Our Ref: Y/95/20/DOC

Town & Country Planning Act 1990 (as amended)
Town and Country Planning (Development Management Procedure) (England) Order 2015
Approval of details reserved by condition imposed under ref Y/13/18/PL relating to Condition Nos 16 -
refuse & recycling bins and 19 - parking.
Street Buildings North End Road Yapton BN18 0DT

Title:
PARKING AND CYCLE STORAGE PLAN

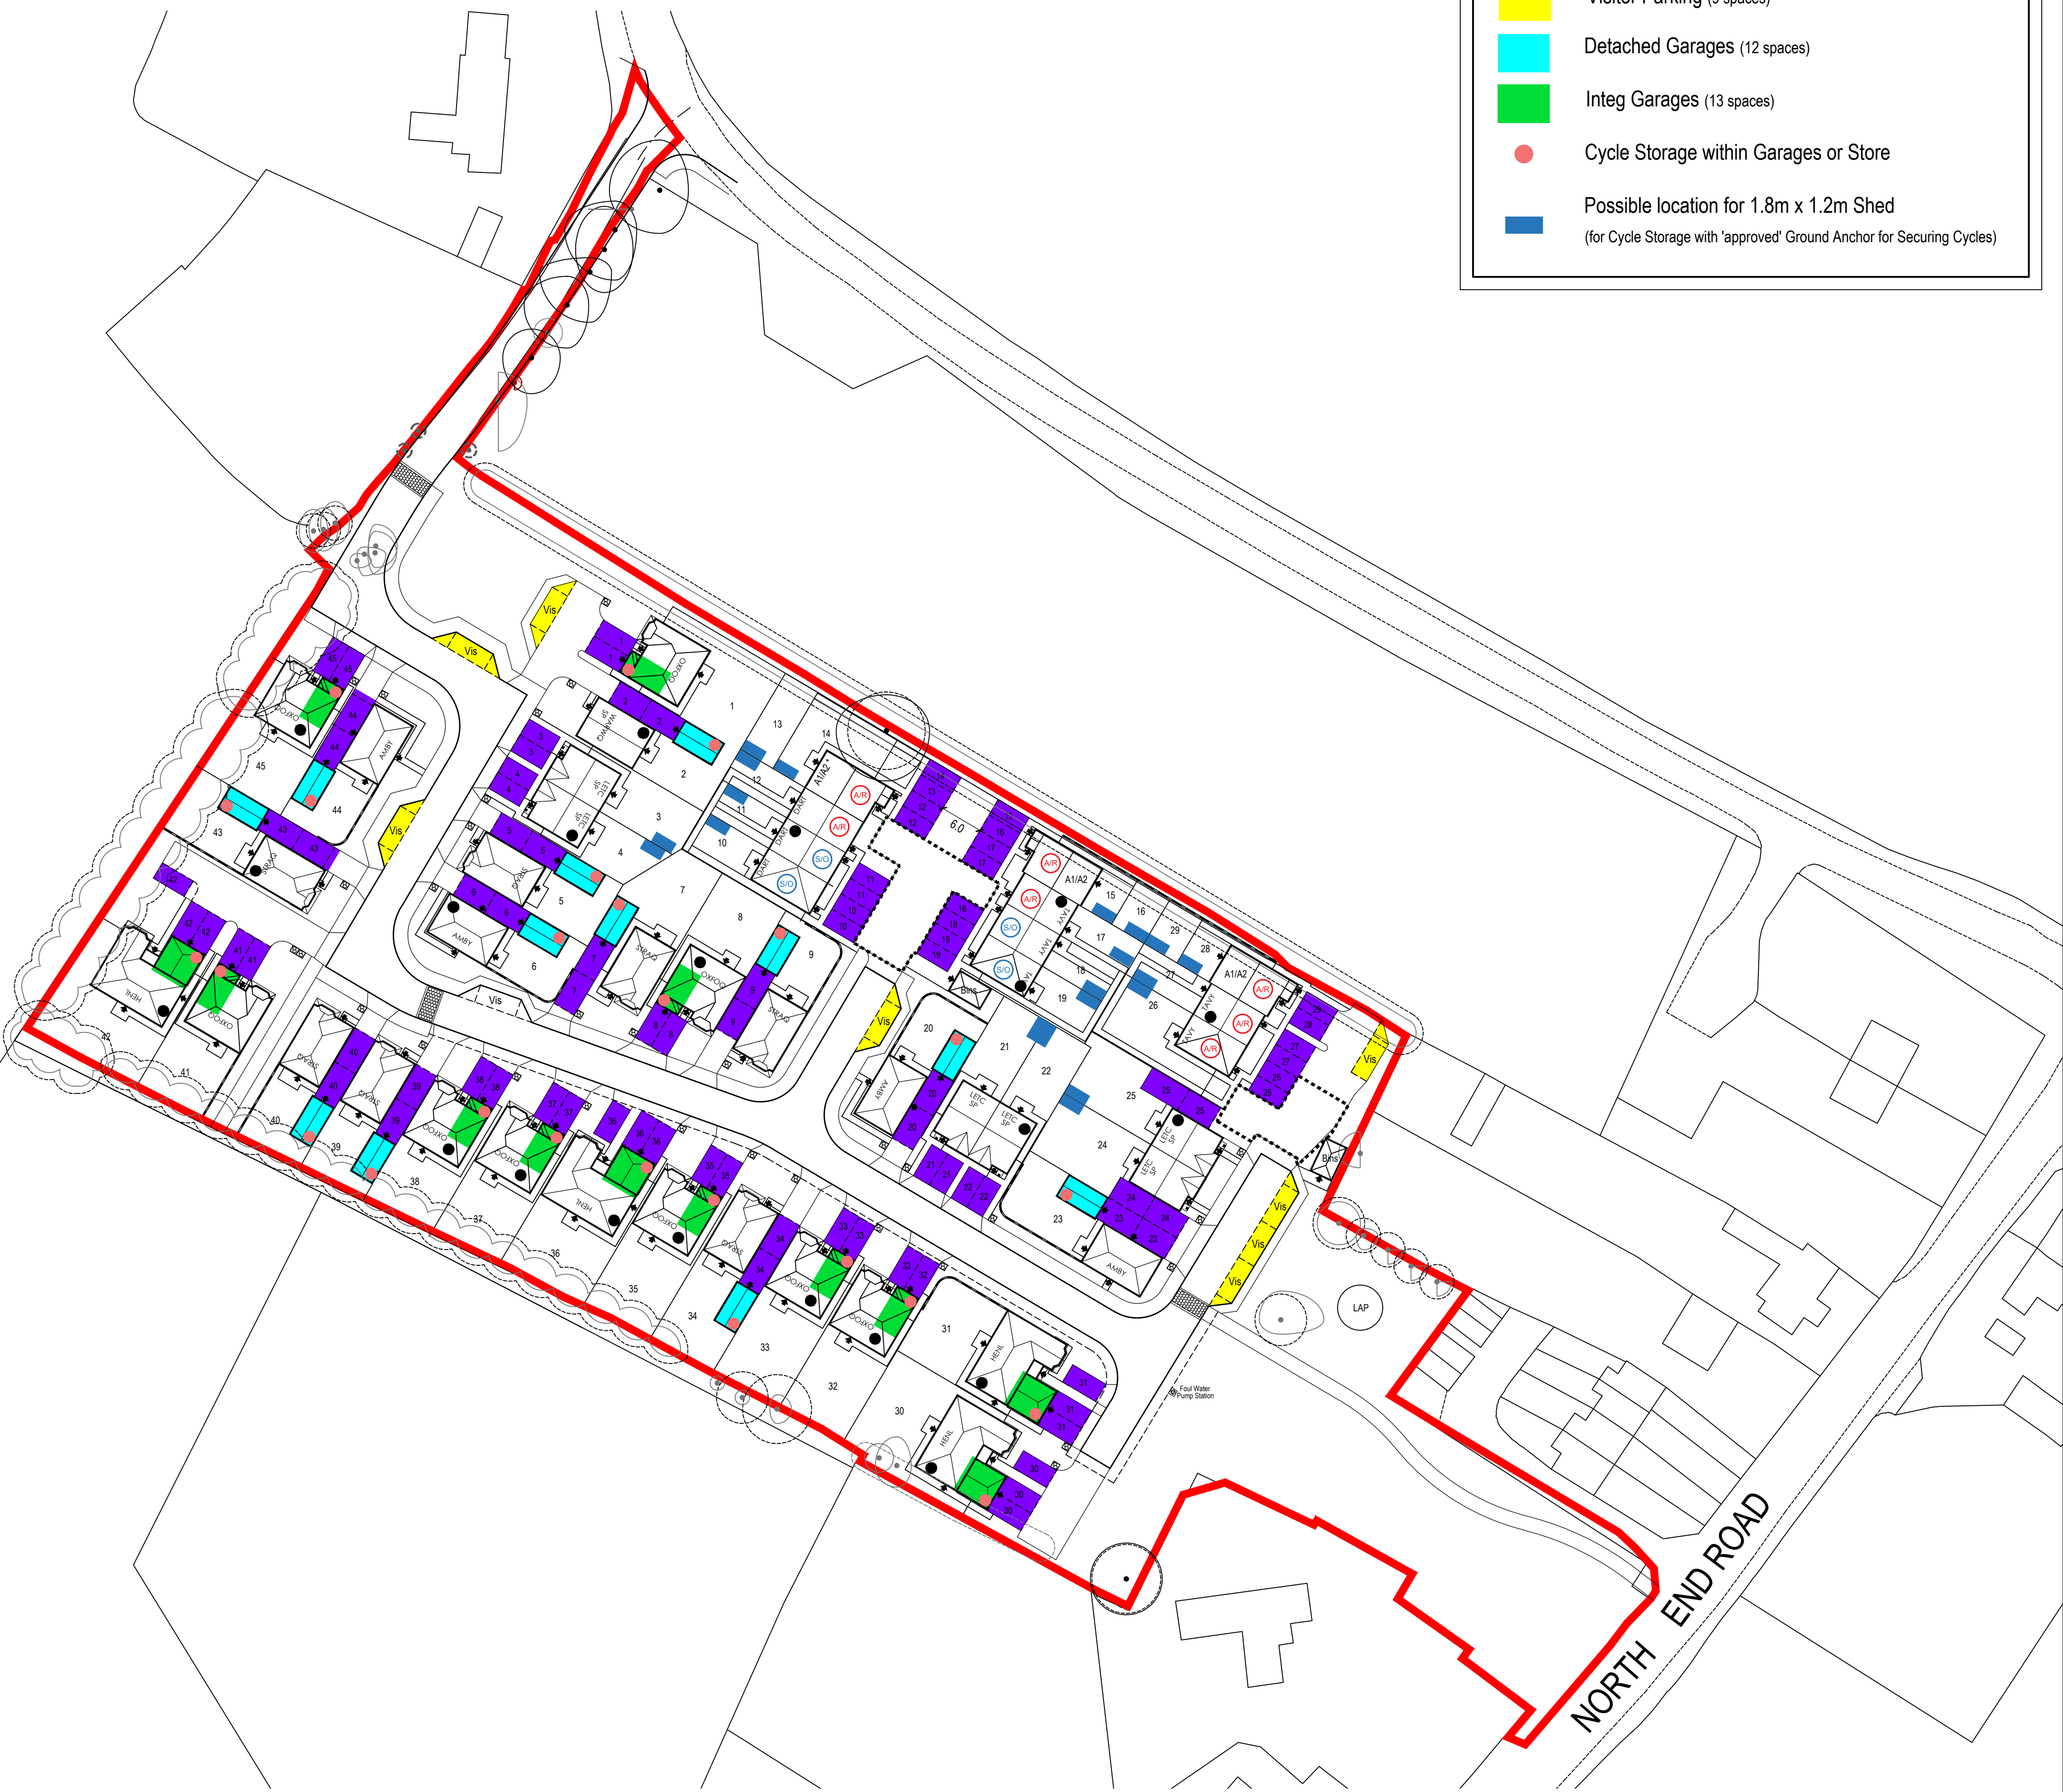
Drawing 072 Rev A "Parking & Cycle Storage Plan" has been appraised by WSCC Highways and is considered to demonstrate car and cycle parking to their satisfaction.

The condition is therefore fully discharged insofar as the submission of details relates and on the understanding that the car and cycle parking spaces, will be implemented in accordance with the approved details, in the positions shown on the approved site layout plan and thereafter permanently retained for the parking of cycles and cars.
